From: Sarah Burrow <Sarah.Burrow@arun.gov.uk>
Sent: 07 May 2021 11:21
To: Planning.Responses <Planning.Responses@arun.gov.uk>
Cc: Simon Davis <Simon.Davis@arun.gov.uk>; Laura Gibbons [REDACTED]
Subject: BN/41/21/DOC (Tars Farm) Engineers Consultation

Engineers Comments Regarding Surface Water Drainage

POND AND DITCH LINING DETAIL
TYPICAL CROSS SECTION
(Scale 1:20)

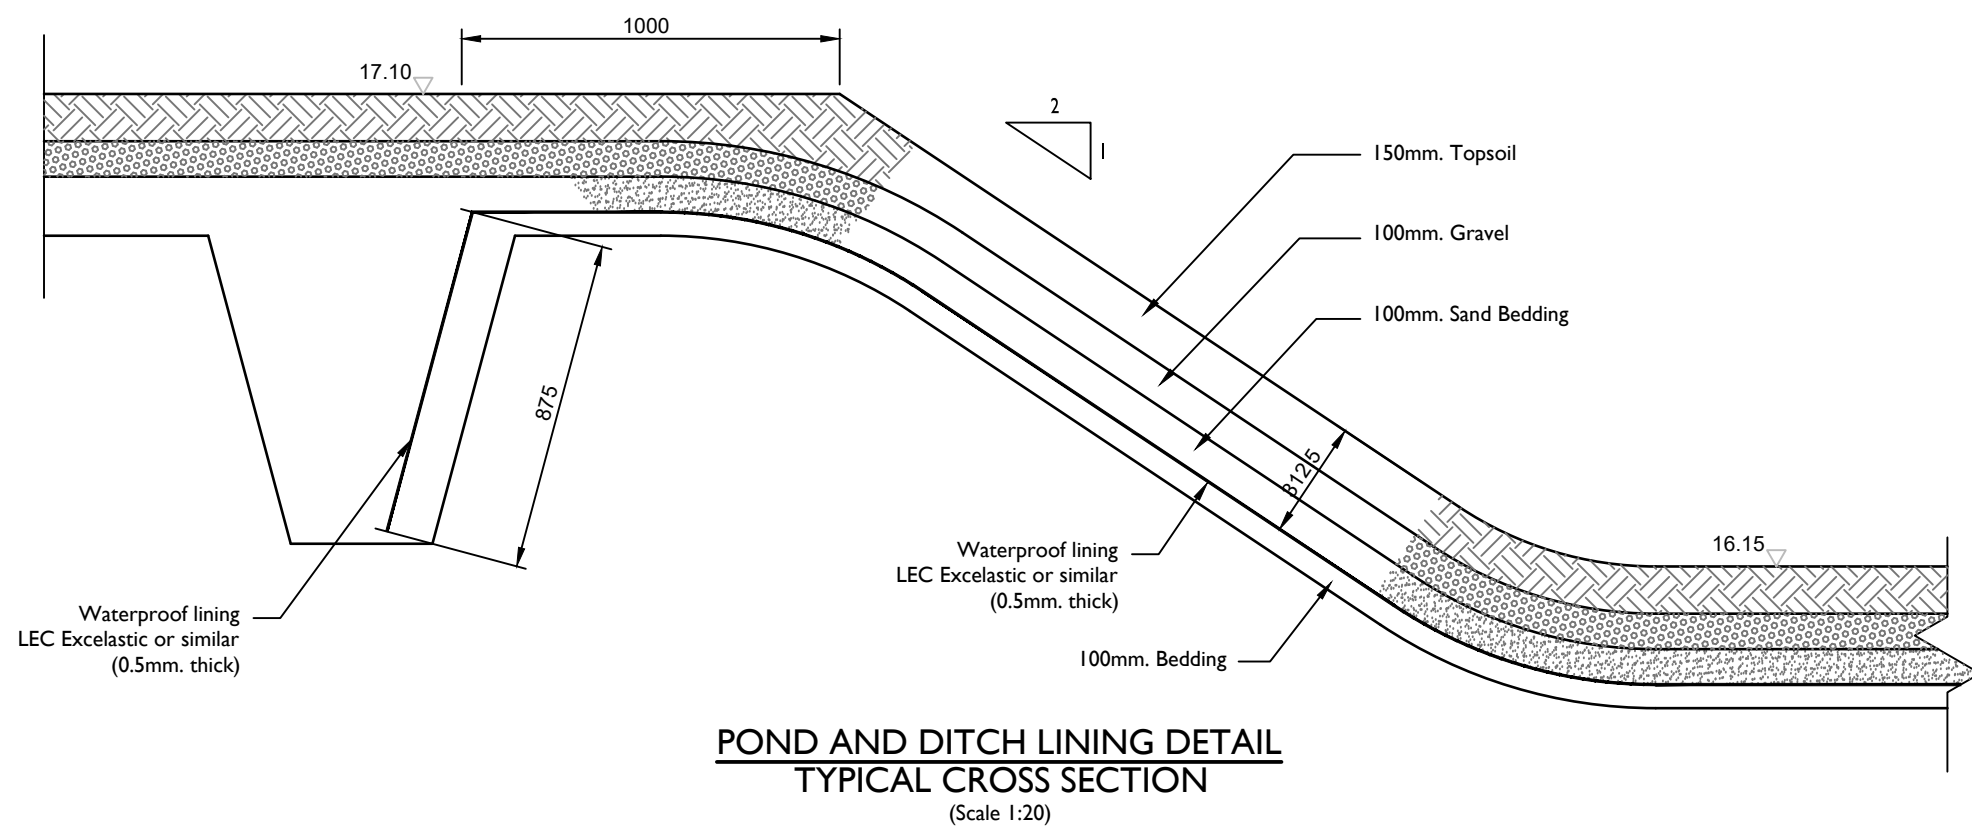
3. Please submit floatation calculations for the proposed basin, (to account for groundwater at ground level). Please also show any necessary alterations to the pond base construction on the construction detail drawings.

9. Please show overlaps and jointing requirements of the impermeable liner on the construction details.
10. Please provide a site specific construction detail drawing of the Hydrobrake flow control device. This should include the product number, invert level, cover level, incoming and outgoing pipe diameters, step rungs and pull handle.
